Second Tee

Lauren Swett <lswett@woodardcurran.com>
To: Jean Fraser <jf@portlandmaine.gov>

Wed, Apr 12, 2017 at 8:19 AM

SHEET TITLE  
SITE LAYOUT, UTILITY AND  
LANDSCAPE PLAN

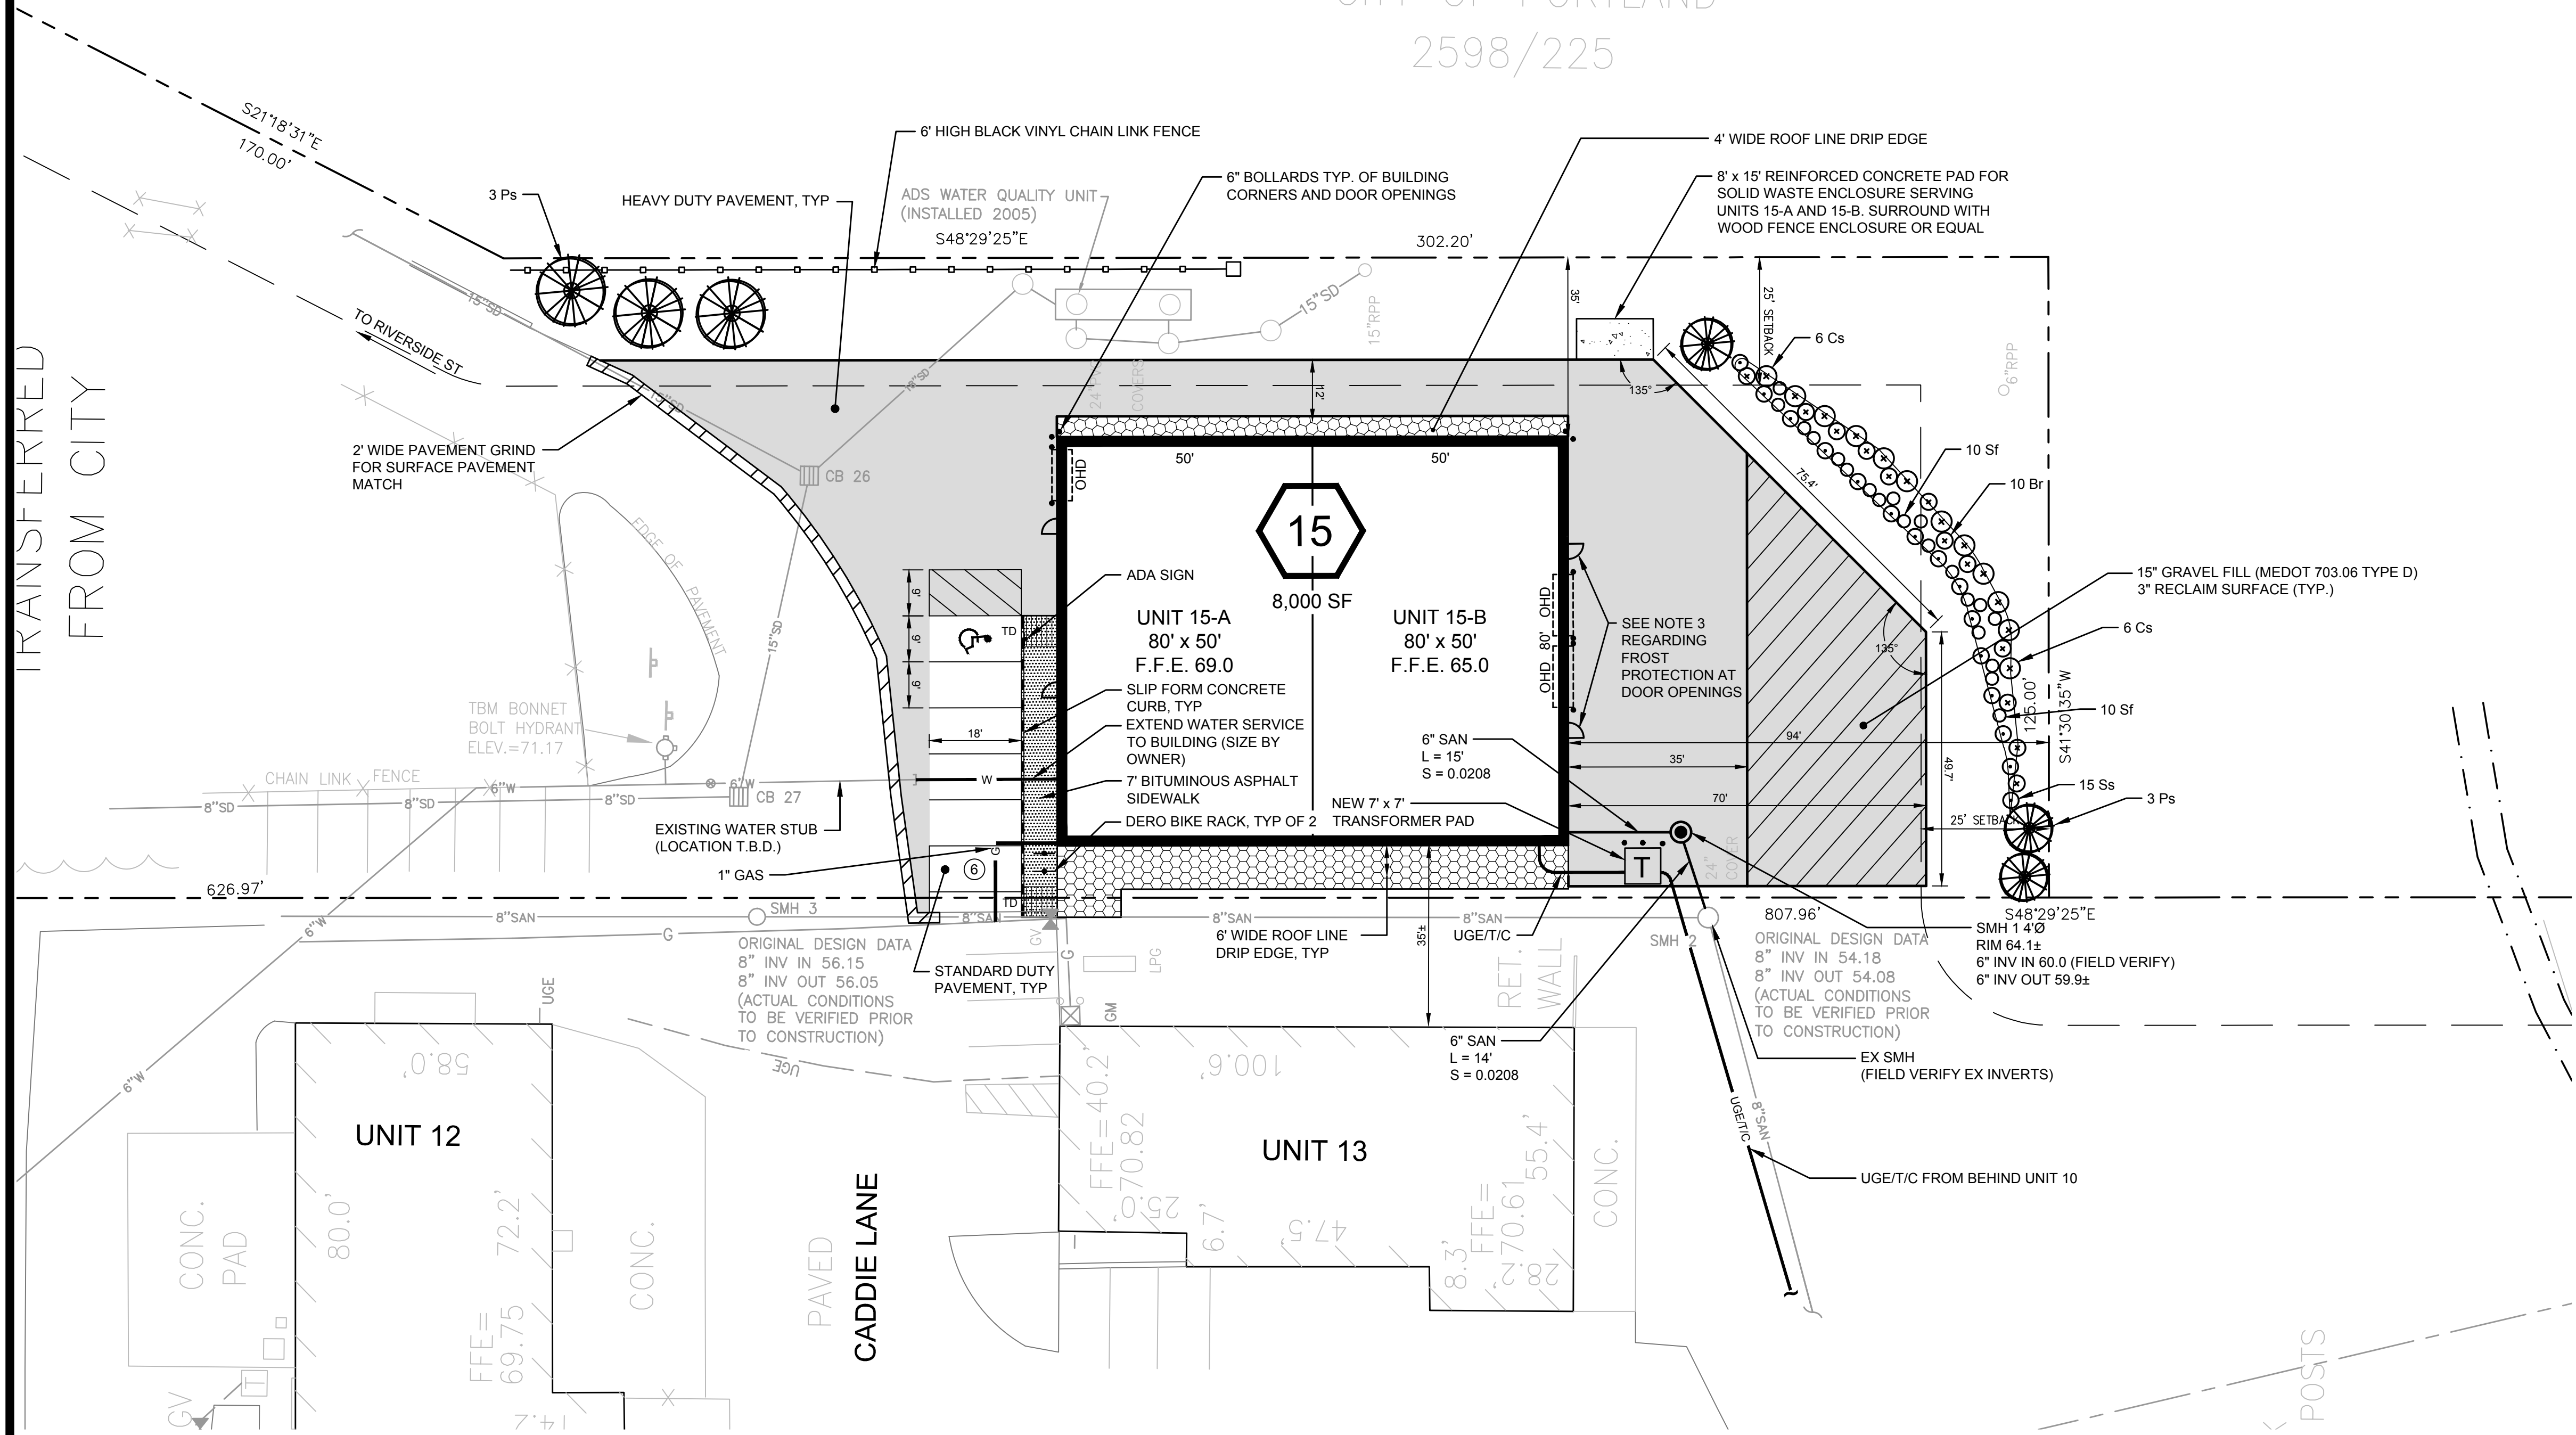
Same standard things on both. The only thing I questioned was the rain garden on Lot 15. It wasn't clear to me if that was new. It discharges to the adjacent property, so I think they do have to provide some discussion of stormwater on that.
